Minsmere Levels Stakeholders Group Open Floor Hearing Transcript

Minsmere Levels Stakeholders Group main areas of concern regarding the Sizewell C development proposal are as follows. The Hard and Soft Coastal Defence, the Permanent and Temporary Beach Landing Facilities and impacts on the inland hydrology of both Sizewell Marsh and Minsmere South Levels as a result of the loss of Sizewell Marsh SSSI land, redirection of the Sizewell Drain, the SSSI Crossing and impacts of the borrow pits and spoil heaps.

B SECTION
SCALE 1:100

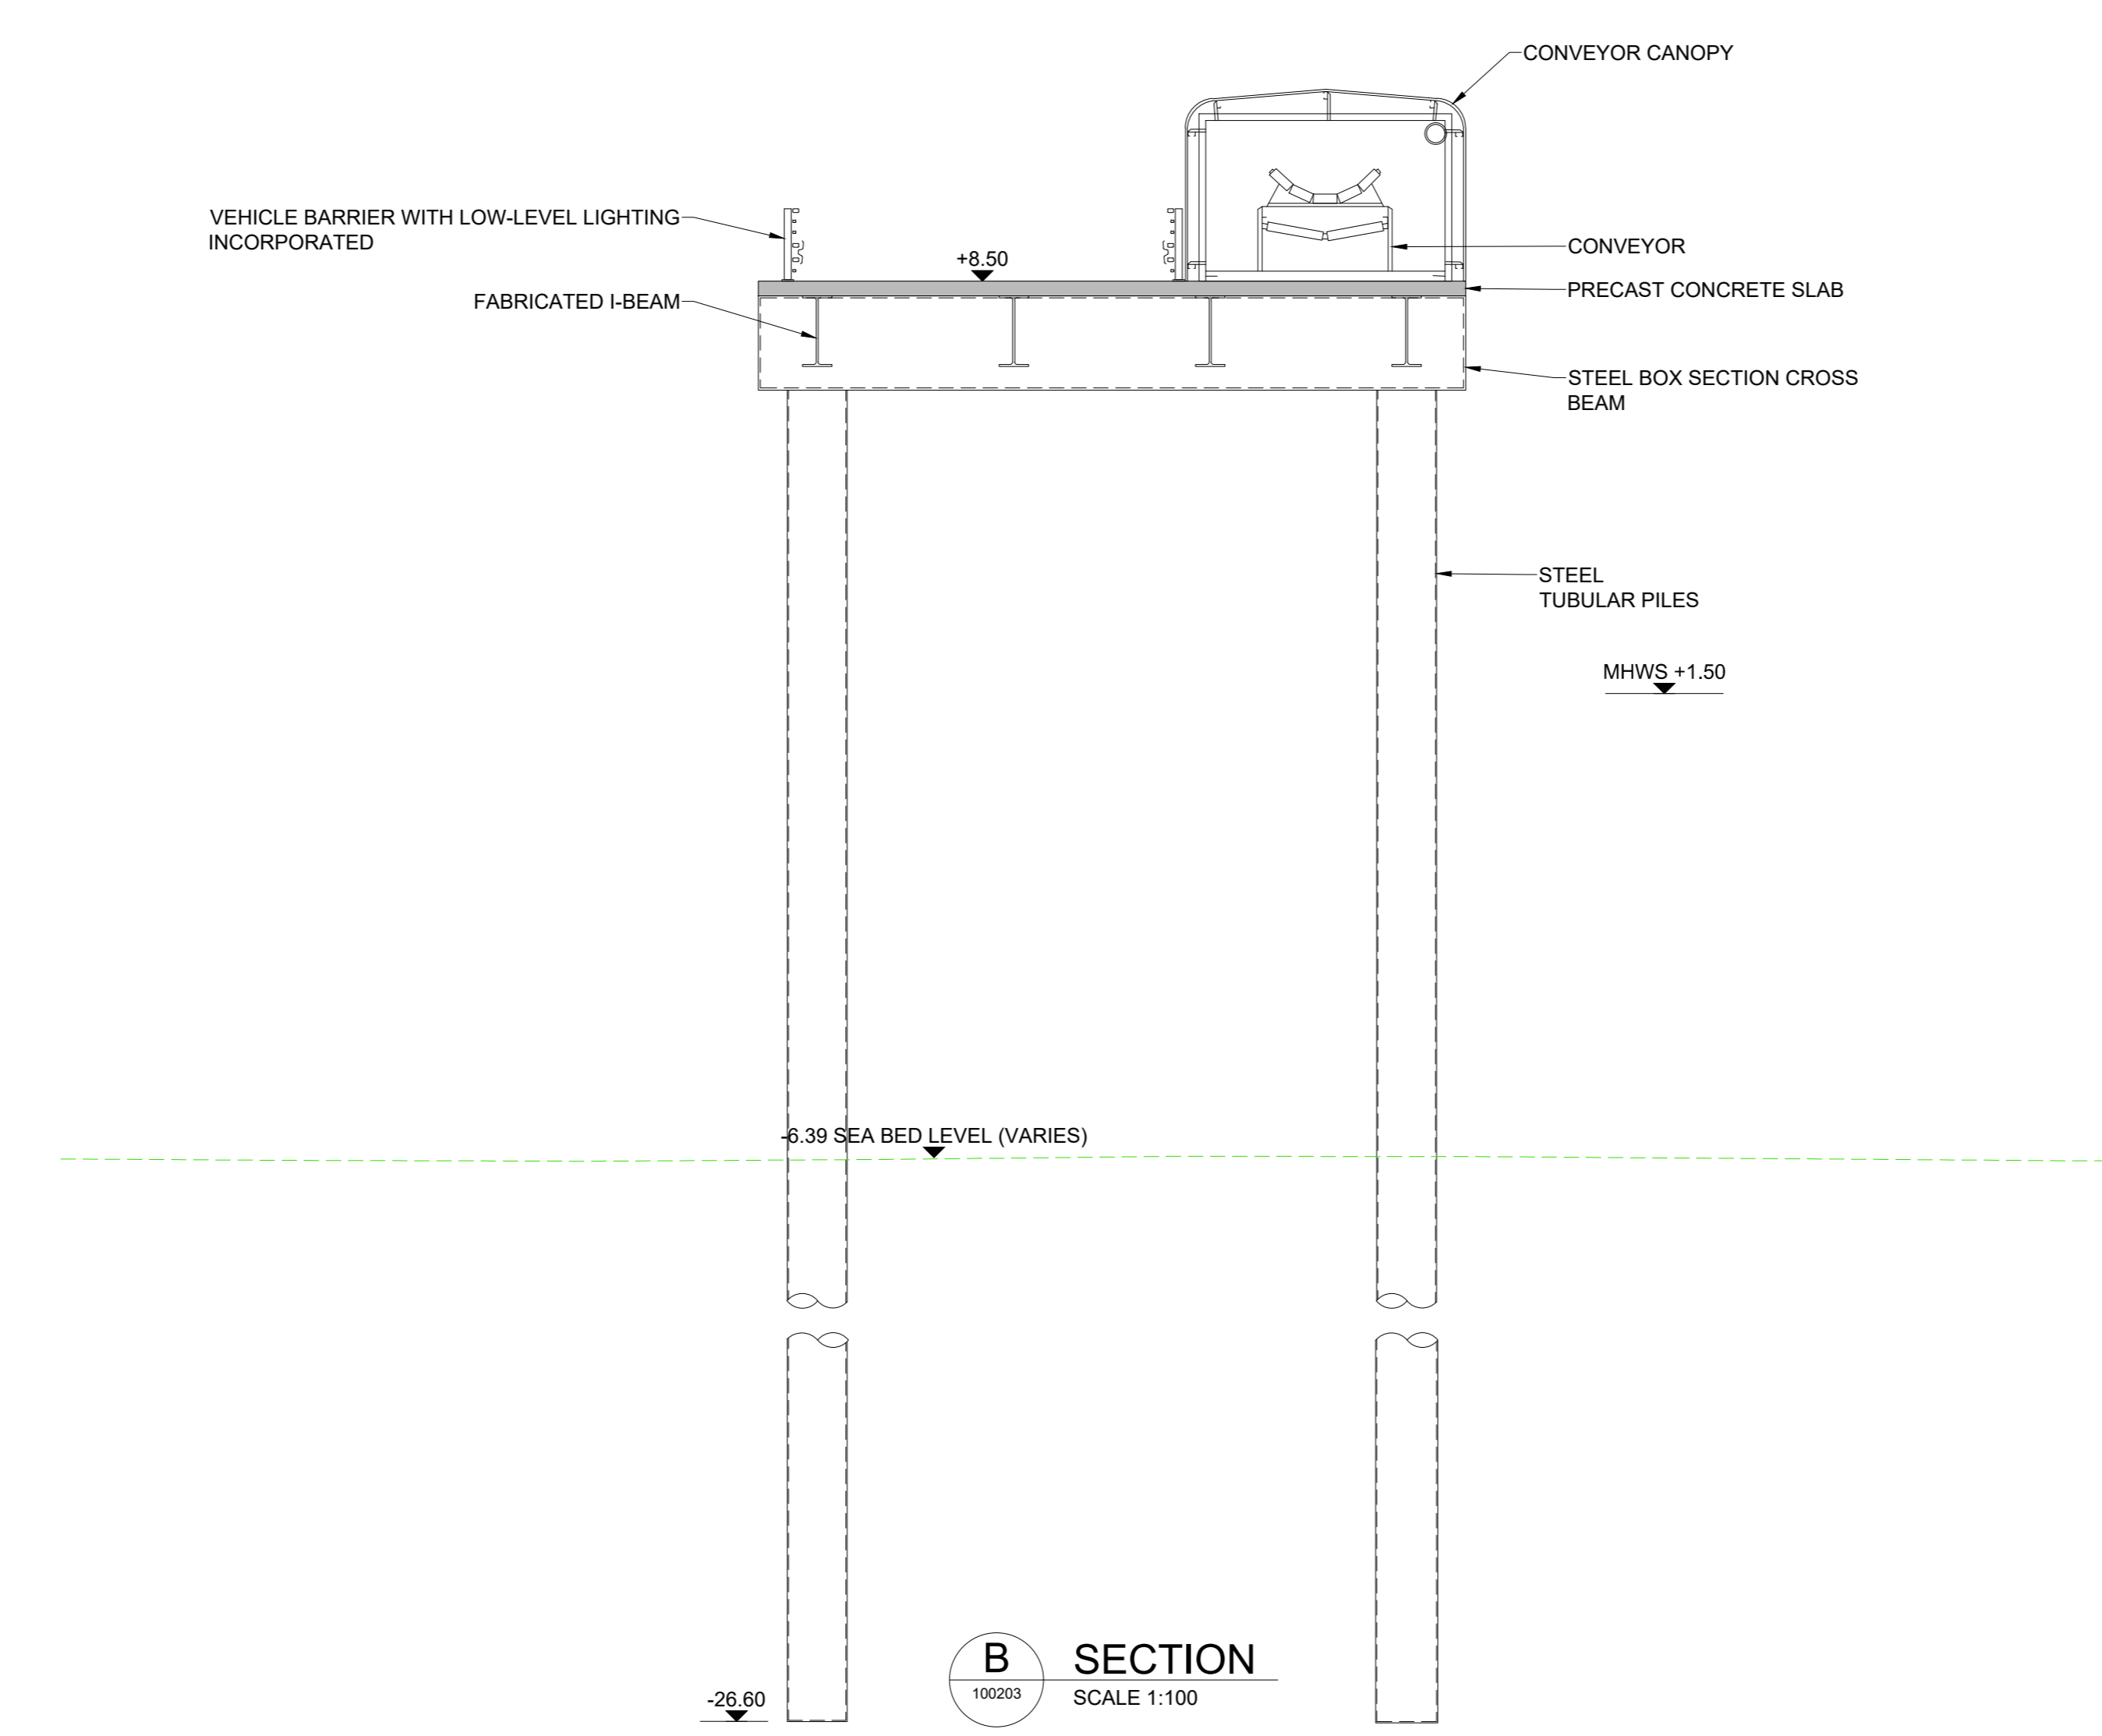
Fourthly: The latest iteration of the SSSI crossing proposes a wider culvert, which still does not provide an open environment for wildlife to transit between Minsmere Southern Levels and the Sizewell Marsh.

There is still effectively a dead zone inside the culvert structure that will be totally dark. The applicant has still not given a valid reason why the three-section bridge structure initially proposed in the earliest consultations, which would allow natural light below the roadway, has been rejected. This despite the fact that Natural England and the Environment Agency and others continue to object to the culvert design.

The SSSI crossing structure, which is piled and surrounded by sheet piling ([PDA-005](#)), will also interfere with the ground and surface water hydrology features of these connected areas. We do not agree with the assessment that the effects will be minor especially given the applicants admission that water levels in the southern Minsmere Levels will be raised, resulting in a flood risk compensation area being created in the southern Minsmere Levels. Modelling results quoted in the updated flood risk assessment ([AS-018](#)) 12.7.4 through 12.7.8 indicates some increase in risk to Minsmere Levels, although a small potential benefit to Sizewell Marsh and on to Leiston as a result of the presence of the SSSI crossing. This implies increased drainage from Sizewell Marsh and interference with the hydrological connection between these two areas. Another consequence of this will be potential
